Review and appraisal of Environmental Impact Assessment Report Chapters for proposed amendments to previously permitted large-scale residential development at Temple Hill and Temple Road, Monkstown, Blackrock, Co. Dublin.

Figure 7.14 - Hydrogeological cross section A-A'

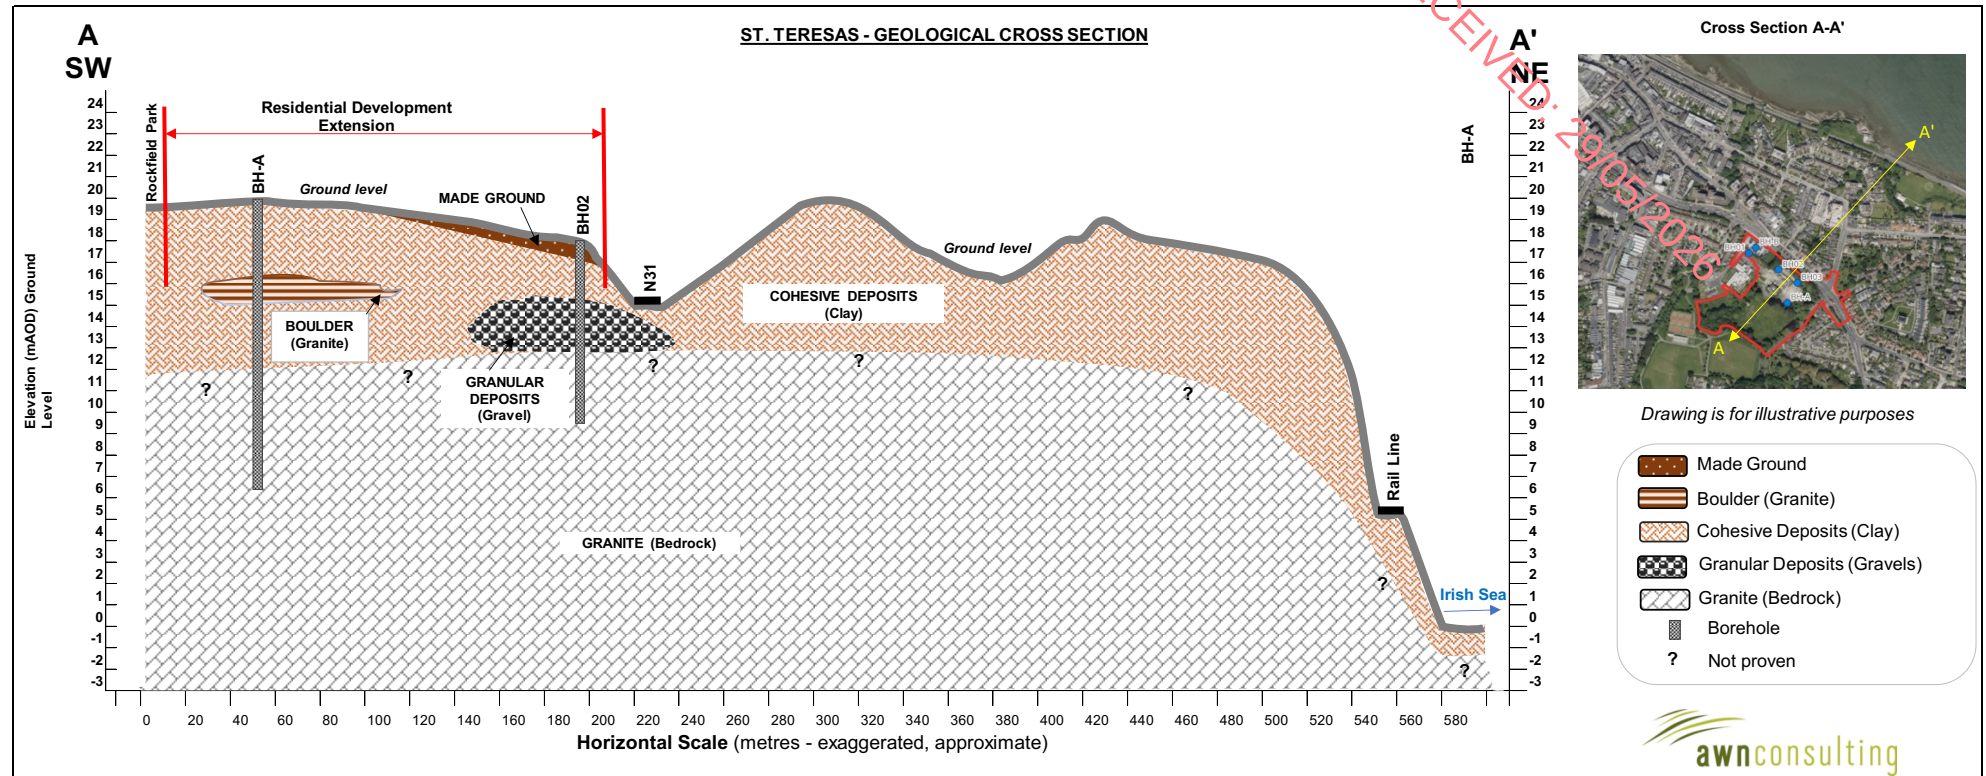
Satisfactory?	No	
Compliance with Planning Policy and Environmental Legislation	No	
Deficiencies Identified	The potential impact from the proposed piled foundations has not been assessed.	
Suggested Request for Further Information	The chapter does not assess the potential impact to bedrock from the proposed piled foundations. The CEMP states "piling / coring through rock may be required to allow excavation of the basements in the strata above the rock in accordance with the proposed design." The potential impact to land, soils, geology and hydrogeology from the proposed piled foundations should be assessed and associated mitigation measures should be specified, if required.	
Recommended Planning Conditions	Prior to the commencement of any works associated with the development hereby permitted, the developer shall submit an updated, detailed Construction Environmental Management Plan (CEMP) for the written agreement of the planning authority. The CEMP shall incorporate as a minimum details for the following: collection and management of construction waste, surface water run-off from the site, management of noise emissions and all environmental management measures to be implemented during construction. A dedicated process for recording all complaints and mitigation measures implemented shall be defined in the CEMP. A record of daily checks that the construction works are being undertaken in accordance with the CEMP shall be kept at the construction site office for inspection by the planning authority. The agreed CEMP shall be implemented in full in the carrying out of the development. REASON: In the interest of landscape and environmental protection, residential amenities, and public health and safety. All materials to be removed from the development site shall be tested in accordance with the relevant environmental standard to determine the appropriate offsite reuse or disposal options. This includes analyses to enable the classification of the material as hazardous or non-hazardous. The results of such testing shall be provided to the Local Authority. REASON: In the interest of good material/waste management. All groundwater which is subject to dewatering, and which is proposed to be discharged to the receiving environment shall be tested prior to discharge to ensure it does not contain concentrations of polluting material that results in it exceeding relevant environmental quality standards. The results of such testing shall be provided to the Local Authority. It is noted that in such instances the Applicant is separately required to apply for a discharge licence from the Local Authority and no discharge shall occur without same. REASON: In order to protect water quality.
